Rezoning Transportation Analysis

Petition Number: #2021-256

From: Jake Carpenter, PE
Jacob.Carpenter@charlottenc.gov
980-221-5675

Date	Description
04-12-2022	First Review (AO)
08-22-2022	Second Review (AO)
01-25-2023	Third Review (TM)
03-22-2023	Fourth Review (DR)
04-20-23	Fifth Review (TM)
06-21-23	Sixth Review (DR)
07-26-23	Seventh Review (TM)

SHEET NUMBER:  
**RZ-1**

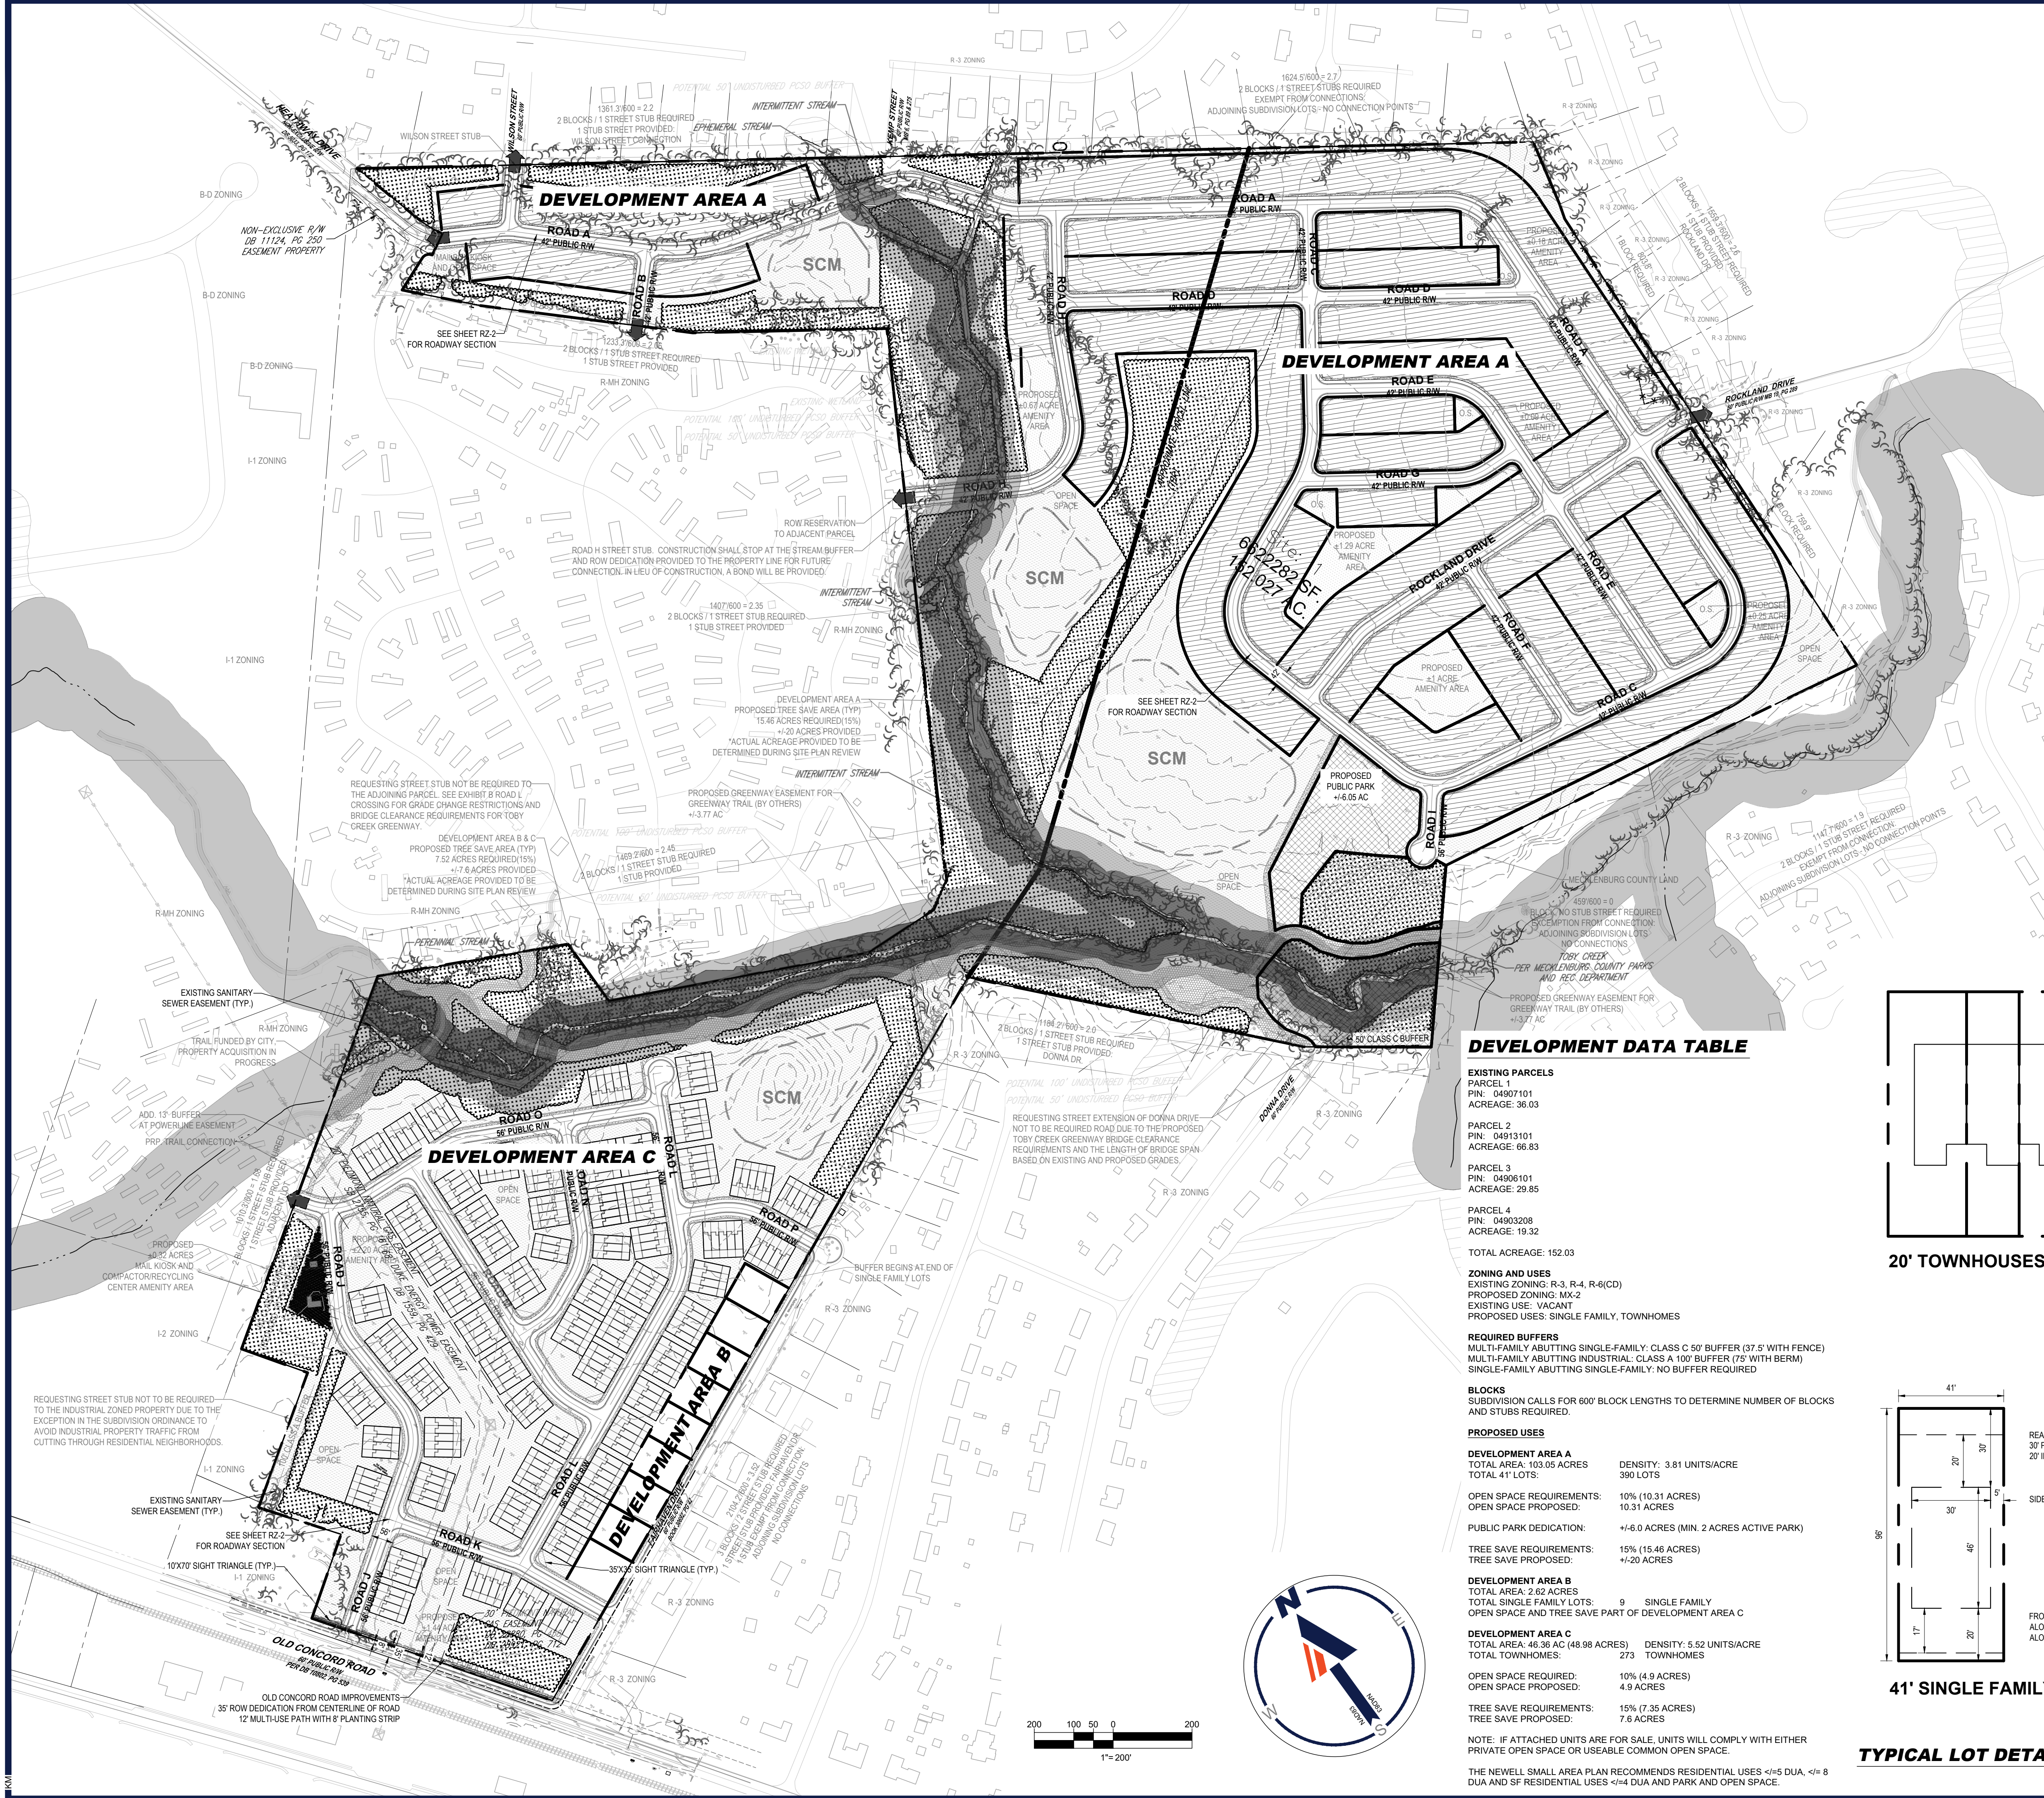
1. ~~Outstanding Comment from 4-12-22: Curbline:~~

~~a. Old Concord Road: Distance from centerline to back of curb: 19 feet~~

~~Label and dimension the curb and gutter from the centerline for each road on the site plan.~~

5. ~~Revise site plan and conditional note(s) to commit to dedicate 35 feet of right of way from the road centerline of Old Concord Road. The site plan shall label and dimension the right of way from the road centerline.~~

6. ~~Revise site plan to commit to construct an 8-foot planting strip, and 5-foot sidewalk on all proposed public streets per Chapter 19 / Chapter 20 of City Code. The site plan shall label and dimension both items from the back of curb and gutter.~~

7. ~~Site plan and conditional note(s) revisions are needed to commit to construct bicycle facilities by locating the curb and gutter 19 feet from the center line of Old Concord Road and installing an 8-foot planting strip and 12' multi-use path to meet the City Charlotte BIKE Policy.~~

8. ~~Revise site plan and conditional note(s) and call out all proposed public or private streets and reference street typical section per CLDSM.~~
9. ~~Revise site plan to reflect most recent alignment/ design of XCLT Orr to Rocky River plans, including all easements acquired by the City through condemnation and approved by City Council on March 28, 2022.~~

Aug 15, 2022  
H:\2021\NCC212802\CAD\DRAWINGS\PLAN SET\REZONING\NCC212802 - RZ-3 - 1\JOB\OUT - RZ-3 CONCEPTUAL SITE PLAN.dwg

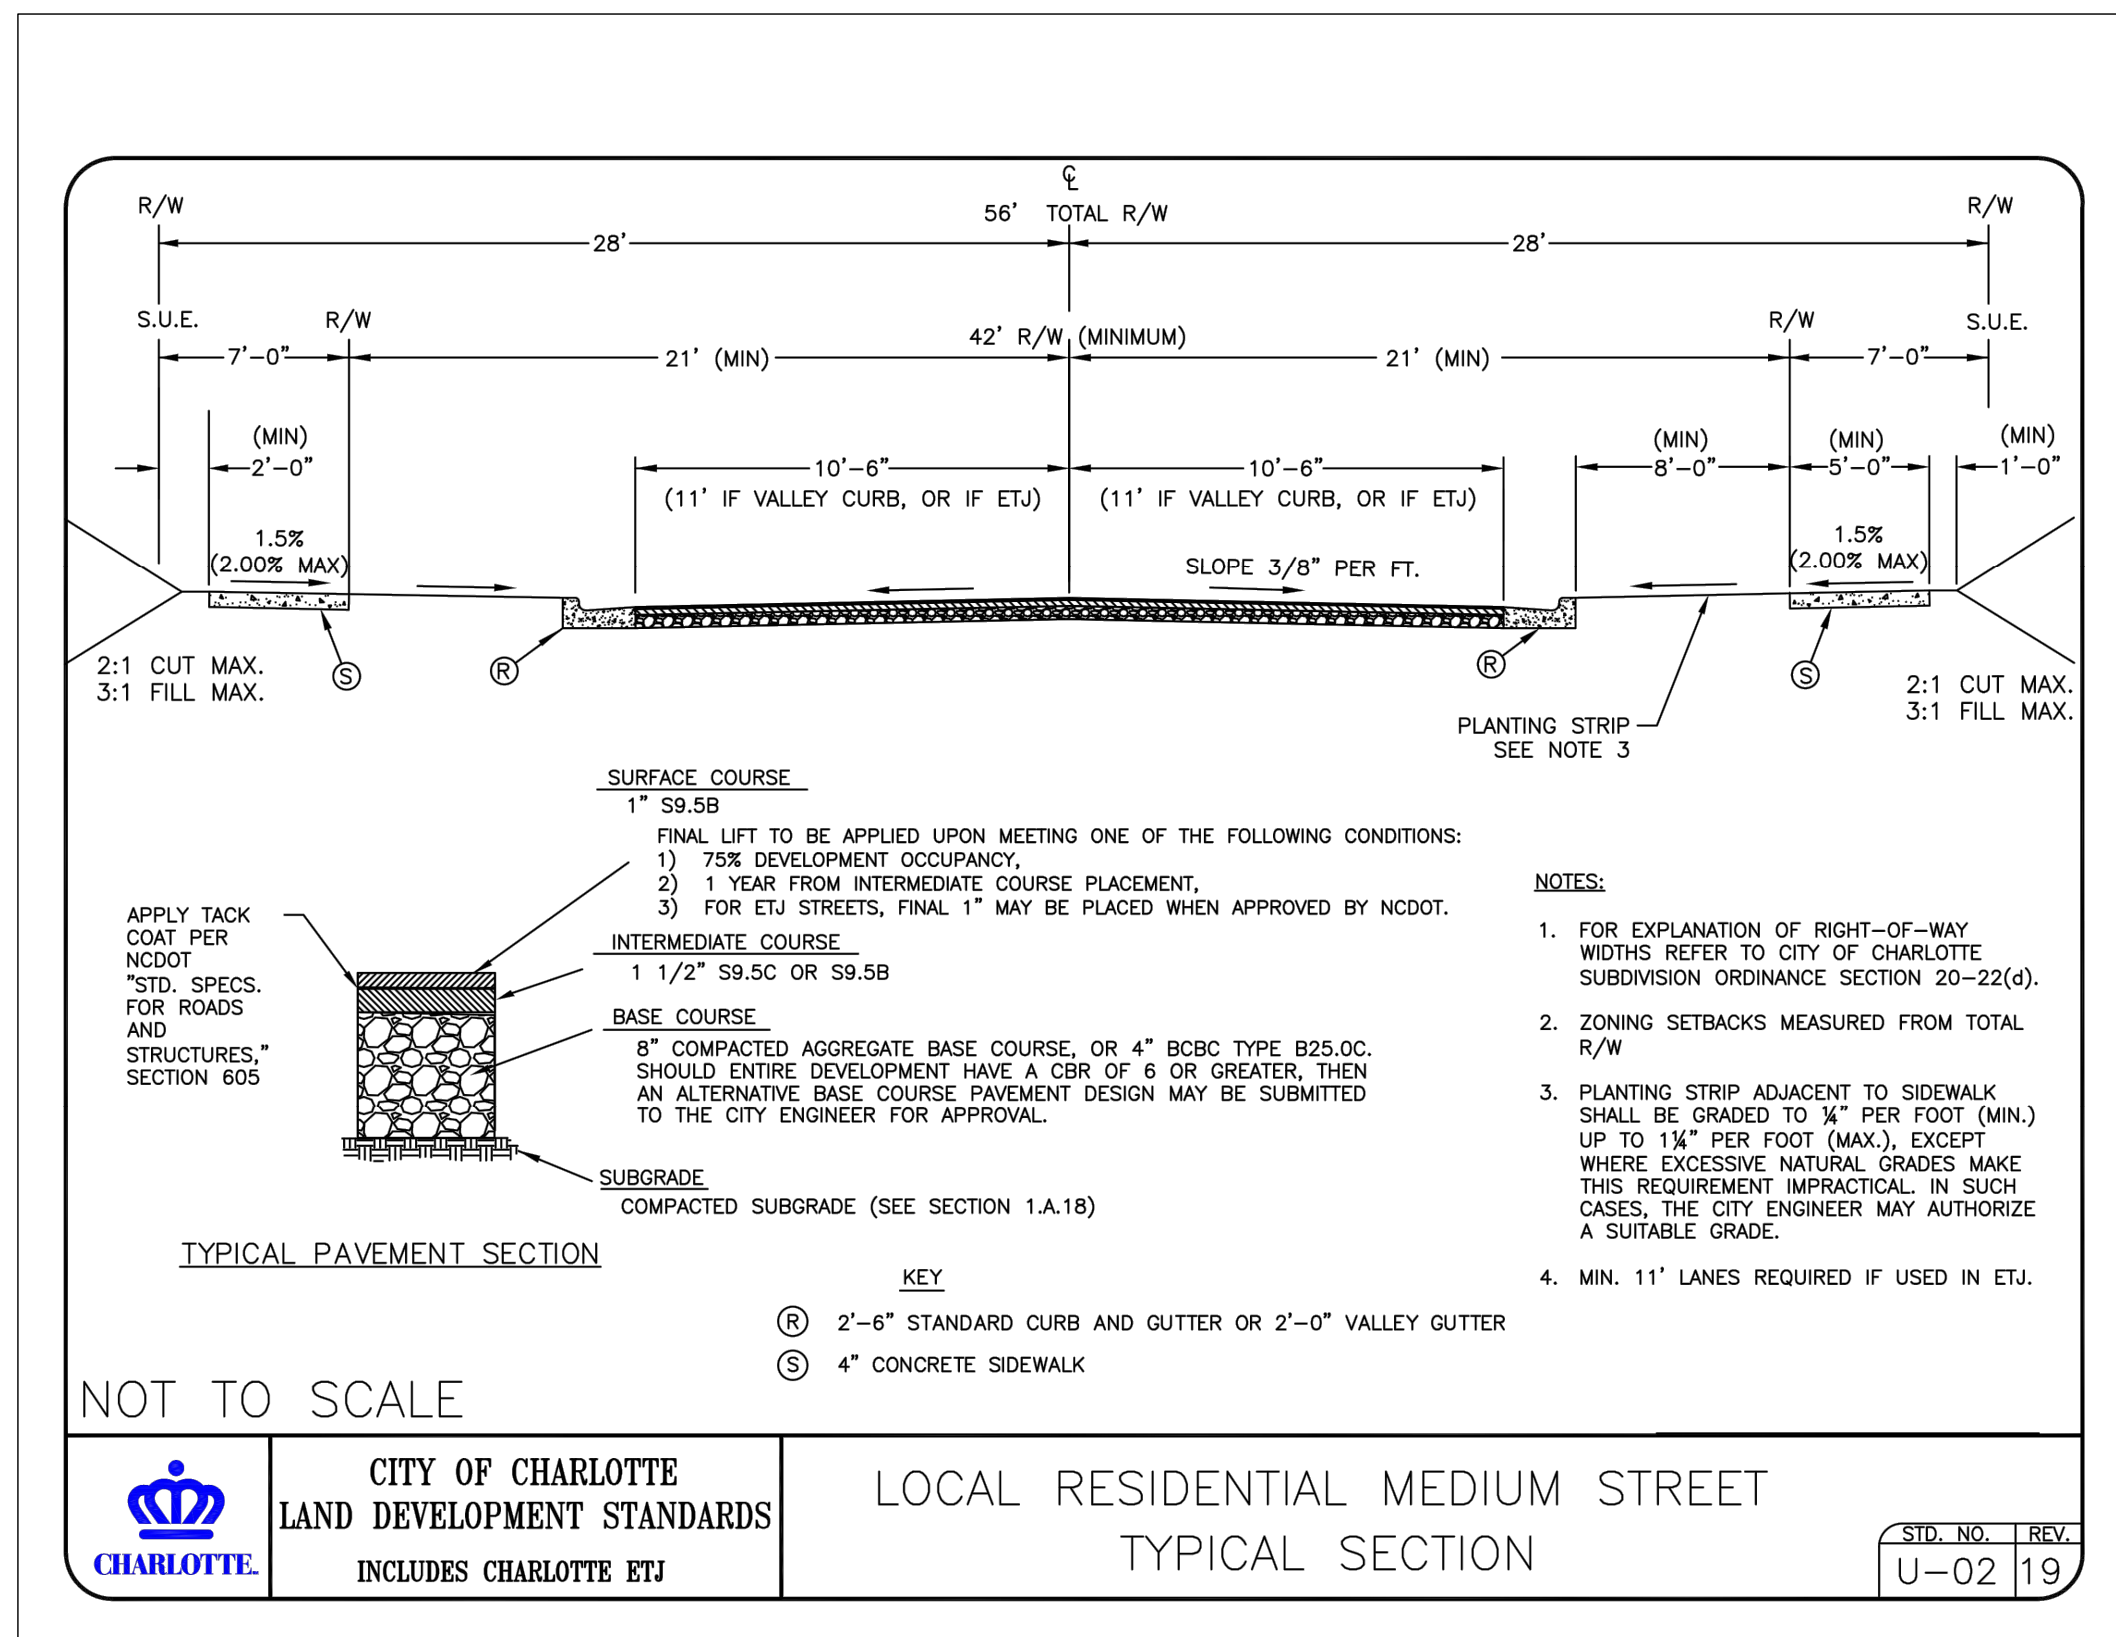
10. **Outstanding Comment from 4-12-22:** ~~Revise site plan and conditional note(s) to commit to constructing a 12' multi-use path connecting Neal Drive to Development Area "A" to provide connectivity from XCLT to eastern leg of Neal Drive.~~

Comment Rescinded (01-25-23): ~~Add multi-use path to site plan sheet RZ-3 and add conditional note to development standards.~~
